WELWYN HATFIELD COUNCIL
PLANNING CONTROL COMMITTEE – 18 DECEMBER 2008
REPORT OF THE CHIEF PLANNING AND ENVIRONMENTAL HEALTH OFFICER

S6/2008/1950/FP

ERECTION OF LOWER GROUND FLOOR SIDE AND REAR EXTENSION, GROUND FLOOR SIDE EXTENSION, FORMATION OF REAR TERRACE AND INSERTION OF TWO REAR DORMERS FOLLOWING DEMOLITION OF EXISTING ATTACHED REAR TRIPLE GARAGE

HOMEWOOD HOUSE, 38 THE RIDGEWAY, CUFFLEY, HERTS EN6 4AX

| Drawing No   | 207/PL/18A Scale : 1:100@A3, 1:50@A1 Date : September 2008 |  |

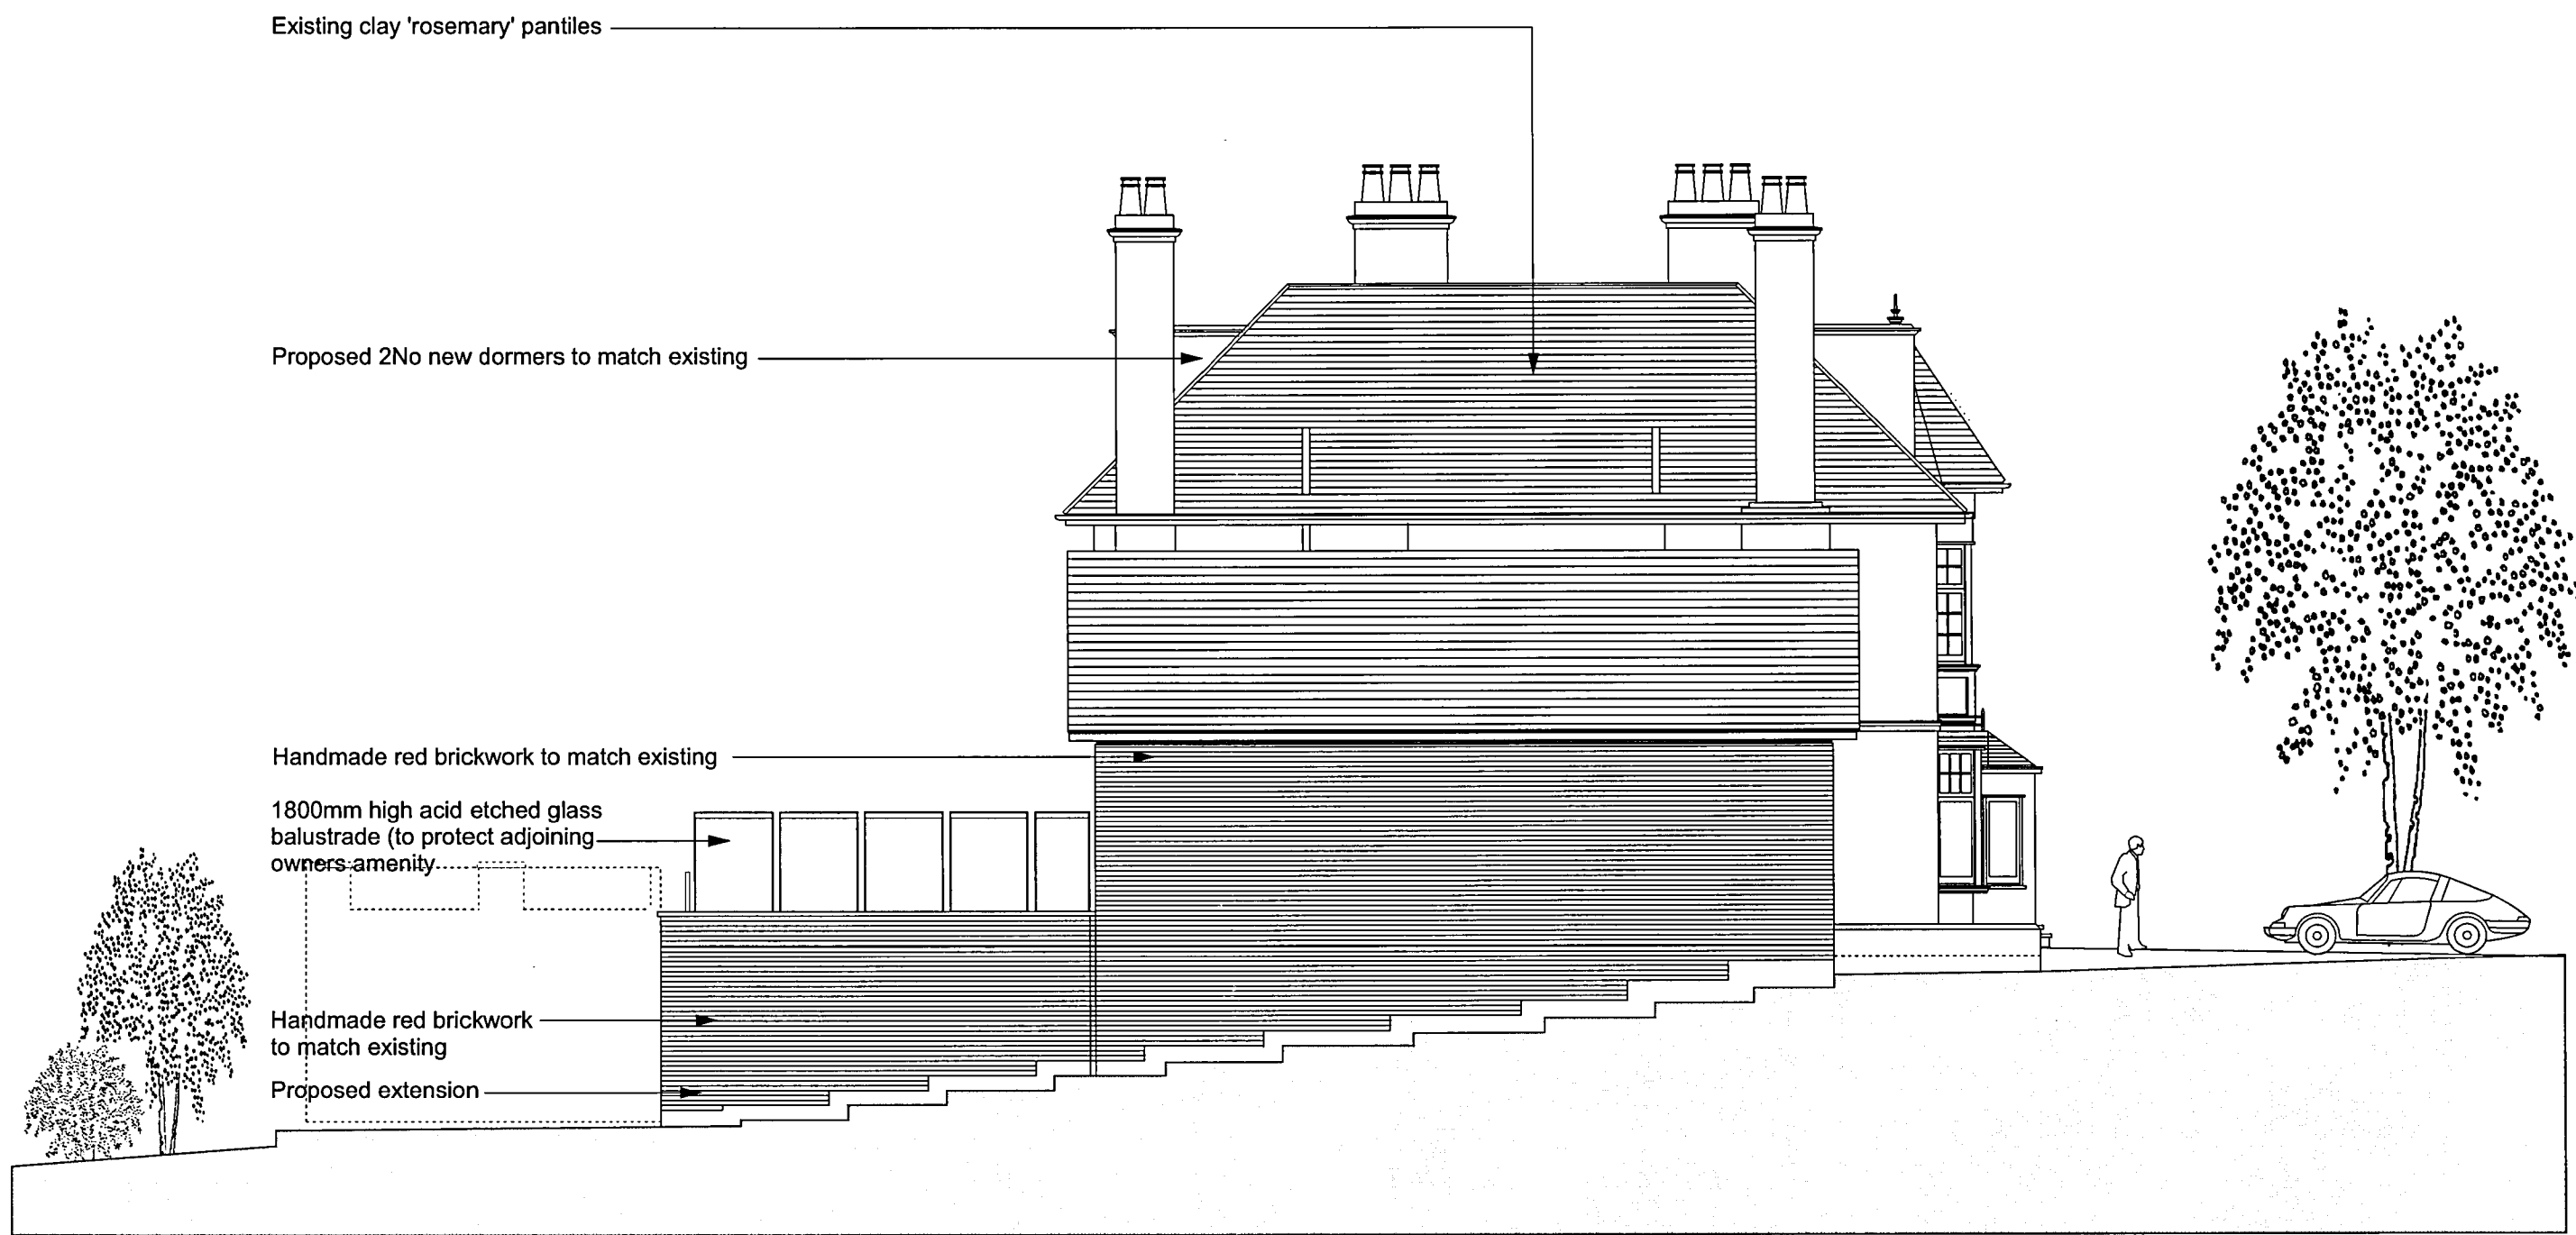
The front elevation plan shows a garage but this is not shown on the description of the works.’

- 8.15 The Parish Council comments on a garage shown on the plans. The detached garage shown on the submitted elevations is outside of the application site and has recently been granted planning permission in the grounds of No.40 The Ridgeway.

Project Homewood House, 38 The Ridgeway, Cuffley  
 Drawing Title Proposed Side Elevation  
 Drawing No 207/PL/19A Scale : 1:100@A3, 1:50@A1 Date : September 2008

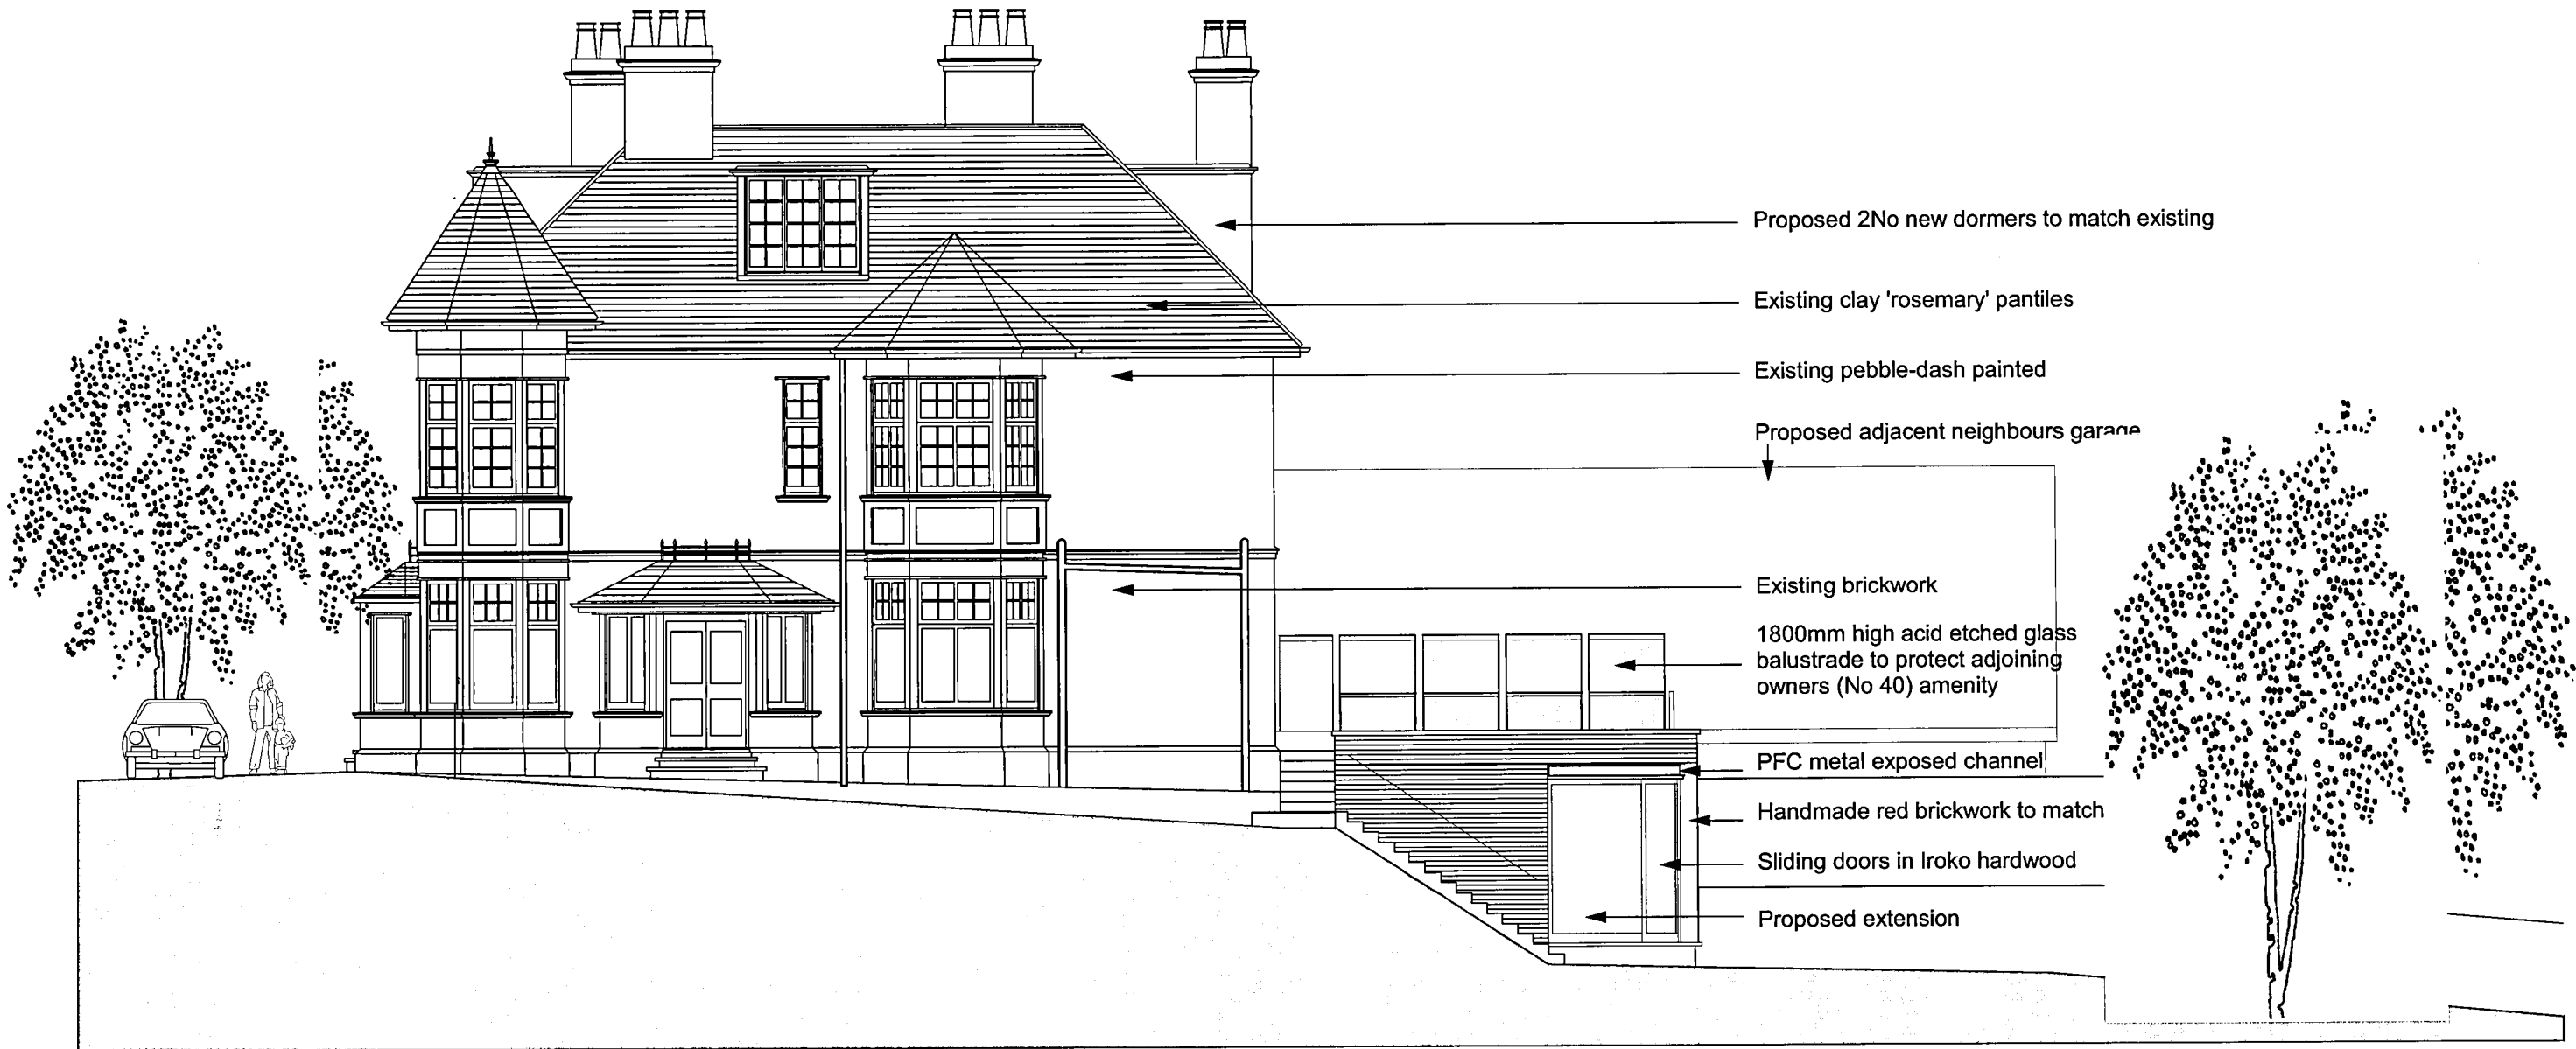
- 8.15 Revised drawings have been received that show an etched glass screen is proposed to the side of the new terrace. It is suggested that this is conditioned to ensure it is installed to protect the residential amenities of both properties. The applicant has brought to the Council's attention that No.40 has recently gained planning permission (S6/2008/0137/FP) for a new replacement garage which is to be located alongside the proposed terrace and so overlooking would be screened by the roof of this neighbour's new outbuilding. However, this has yet to be built and so it would still be reasonable to impose such a condition at this time. Subject to this condition, there are no concerns arising from the impact of the proposed development on adjoining residential amenity. The proposal therefore complies with the amenity requirements of Policy D1 and the Supplementary Design Guidance.
